# OXFORDSHIRE COUNTY COUNCIL'S RESPONSE TO CONSULTATION ON THE FOLLOWING DEVELOPMENT PROPOSAL

**Application no:** 22/02068/REM

**Proposal:** Reserved Matters to 14/01932/OUT: Parcels 1 and 3 for 240 dwellings - appearance, landscaping, layout and scale

**Location:** OS Parcel 7400 Adjoining And South Of, Salt Way, Bodicote

DEVELOPMENT LAYOUT

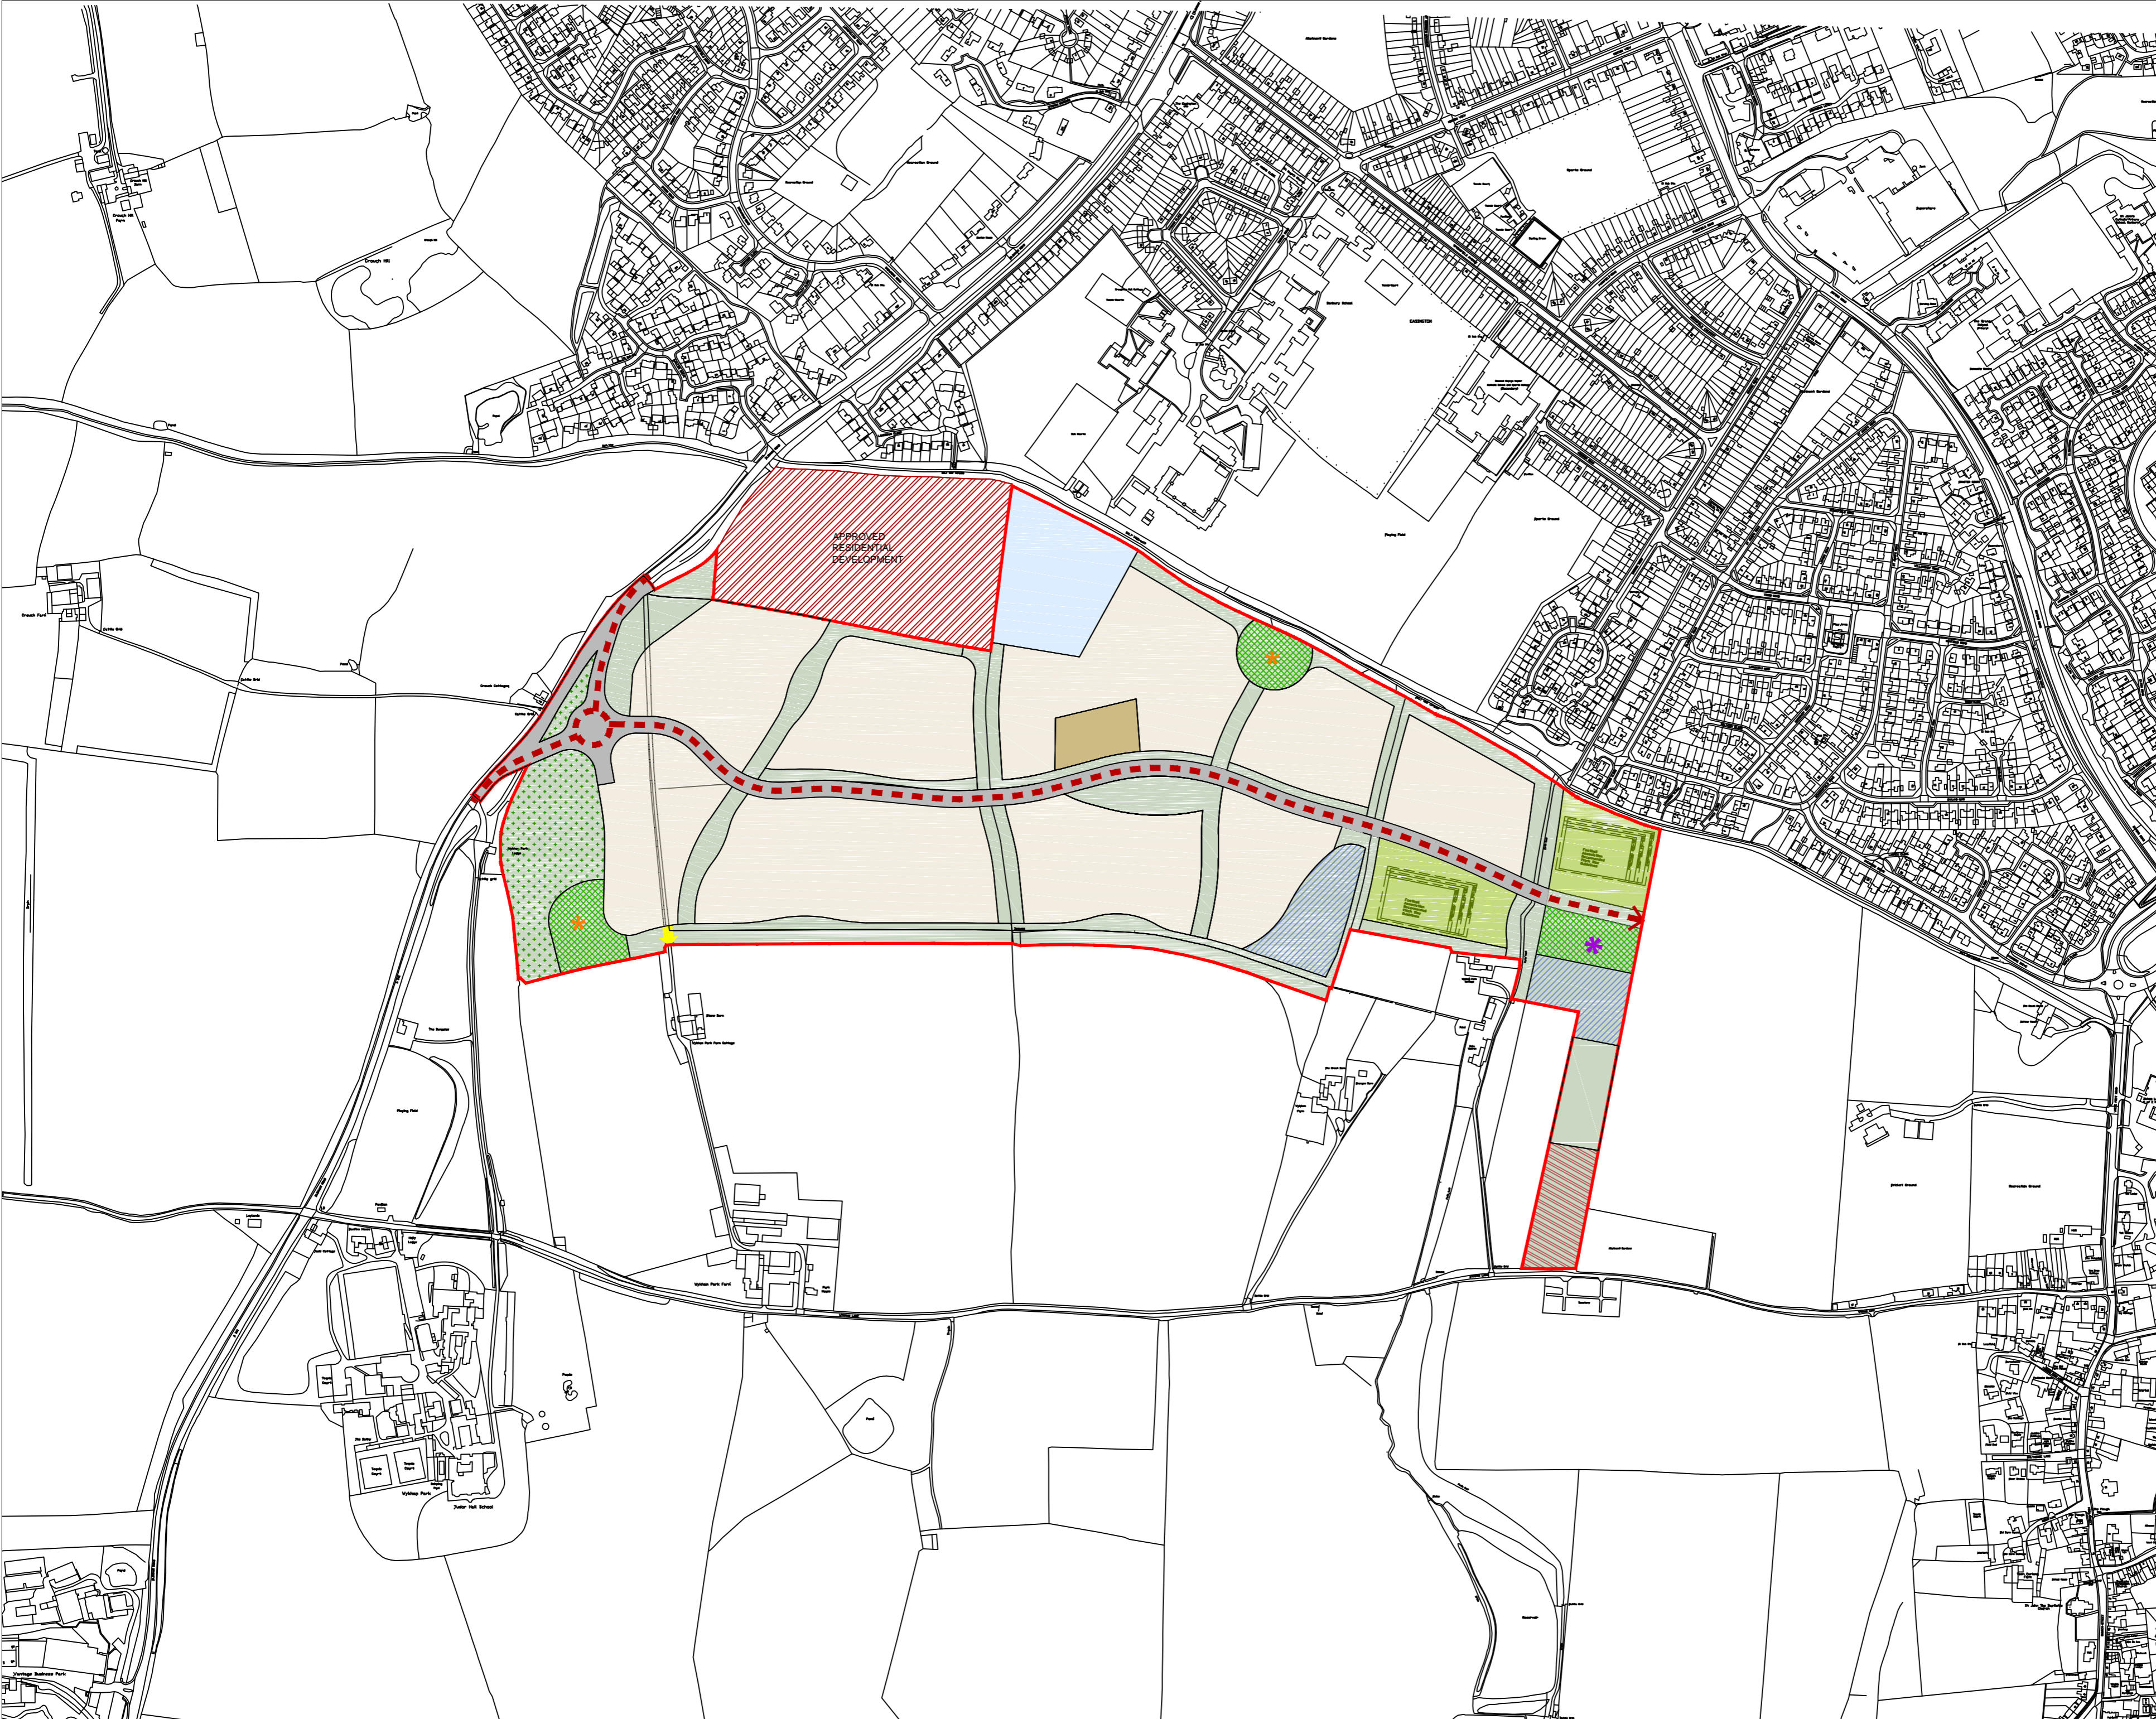
There is no evidence of electric vehicle (EV) charging points on the Planning Layout. EV charging should be provided for each dwelling. **Reason for objection.**

There is a substantial number of dwellings that do not have a garage, and therefore do not have a facility for secure covered cycle storage external to the main dwelling. This should be rectified in the form of sheds or bespoke cycle storage units. **Reason for objection.**

Cycle parking and EV charging points should be provided within residential boundaries. **Reason for objection.**

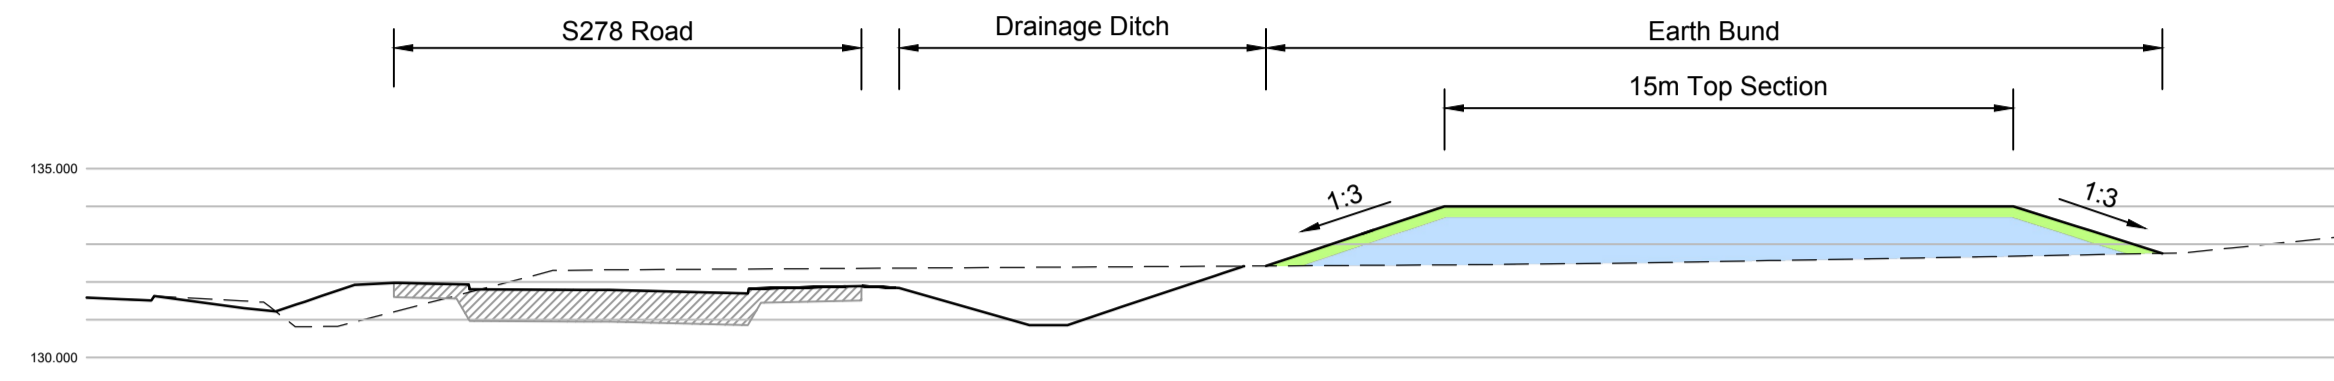
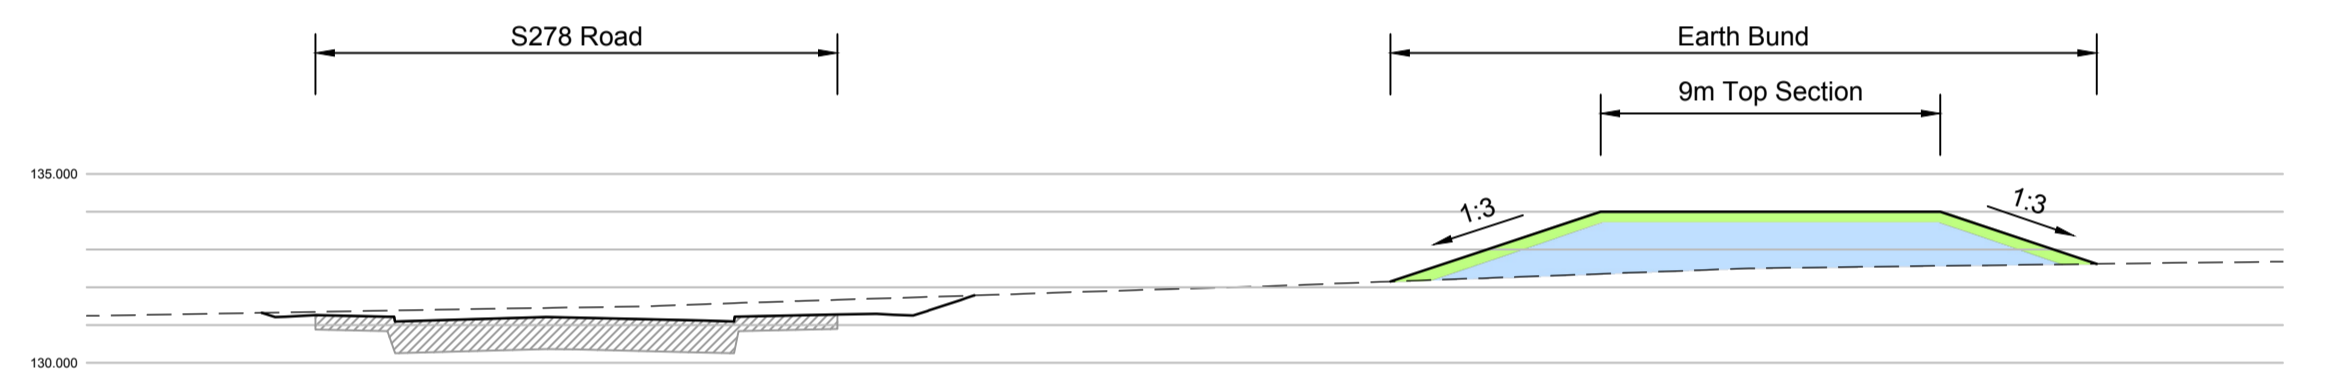
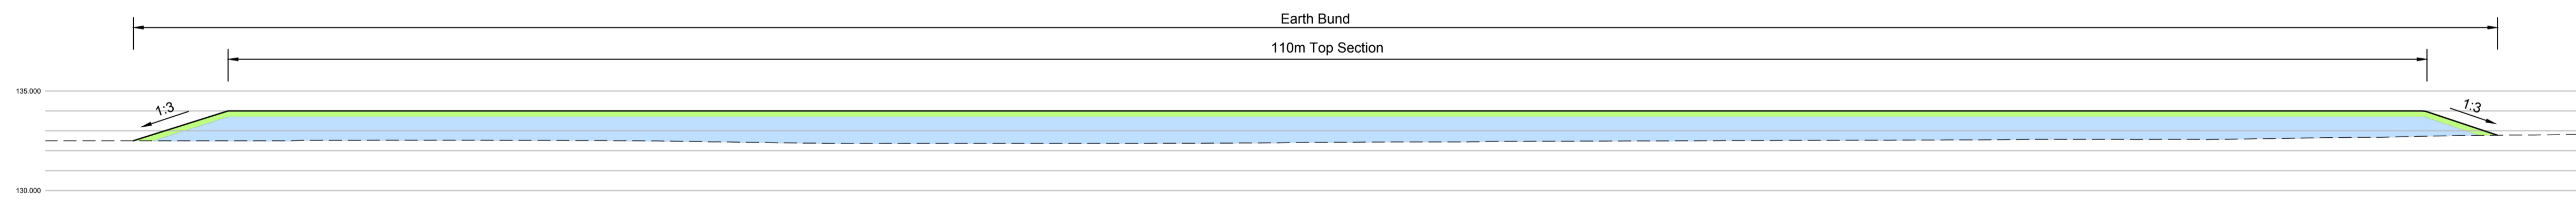
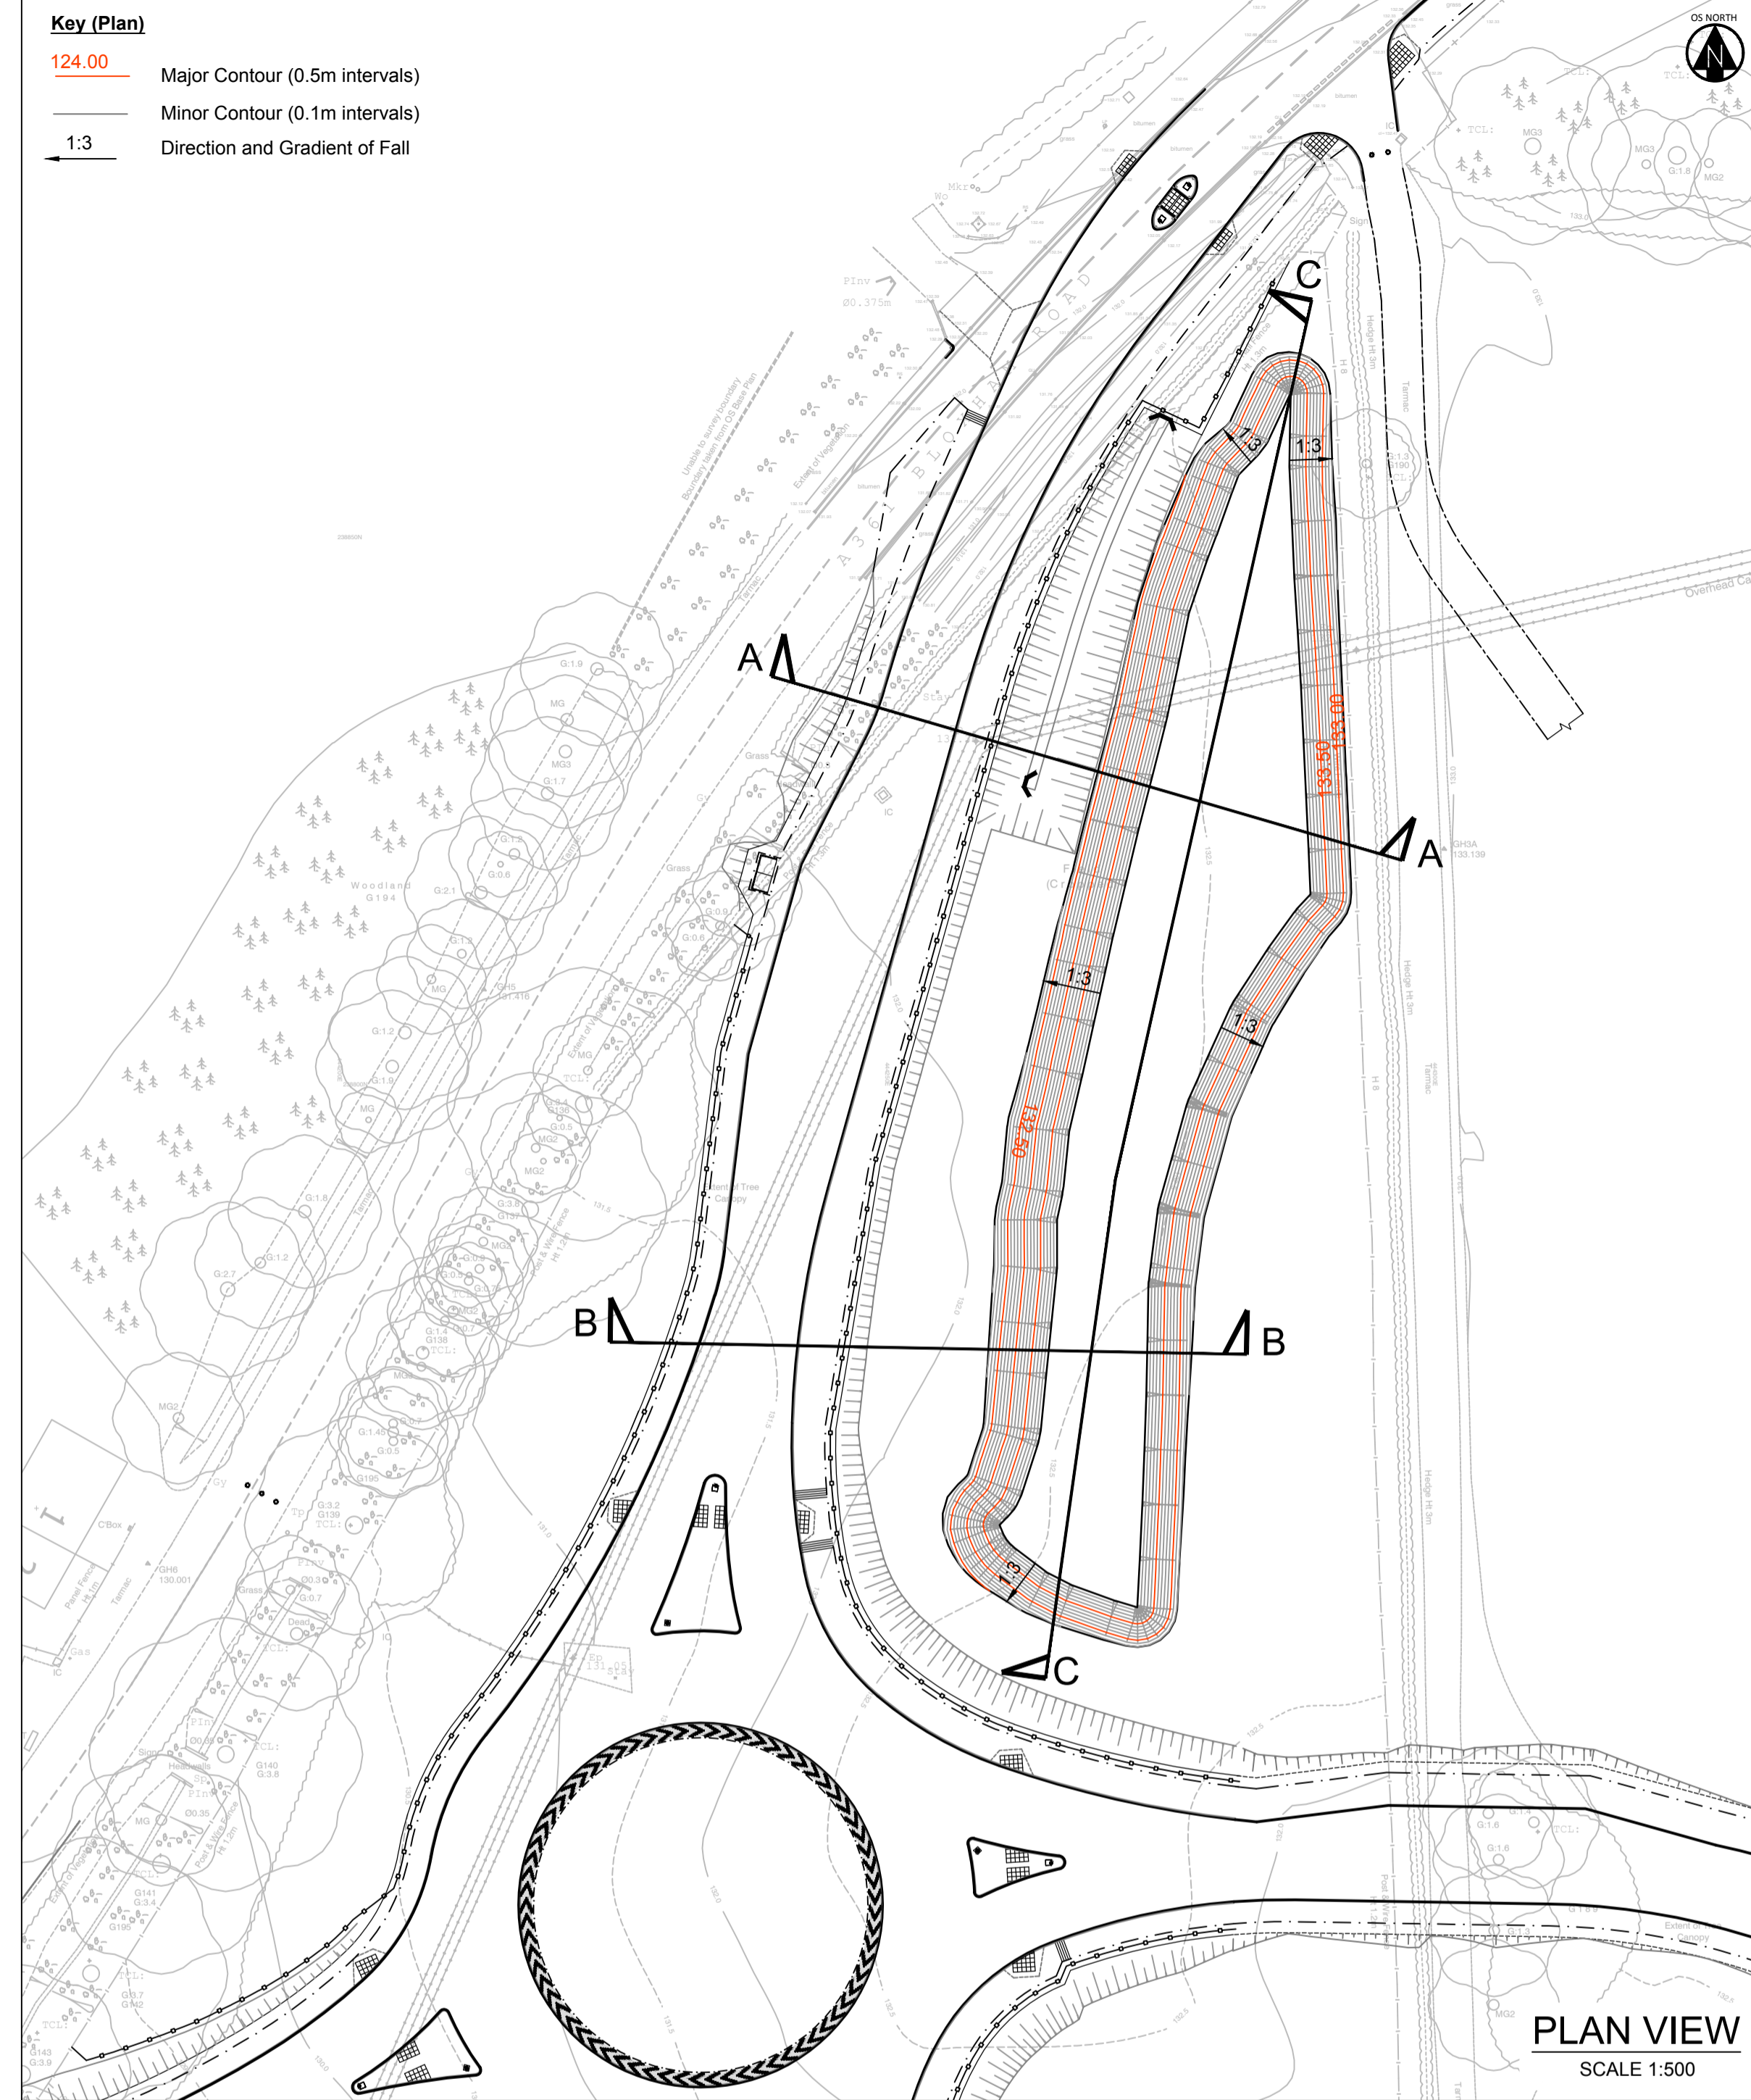
A long section has not been provided and will be required to ensure compliance with the Equalities Act 2010. This must include details of the vertical alignment to determine appropriate carriageway and footway gradients. They will need to be DDA compliant i.e. maximum 1:21 or 5%. **Reason for objection.**
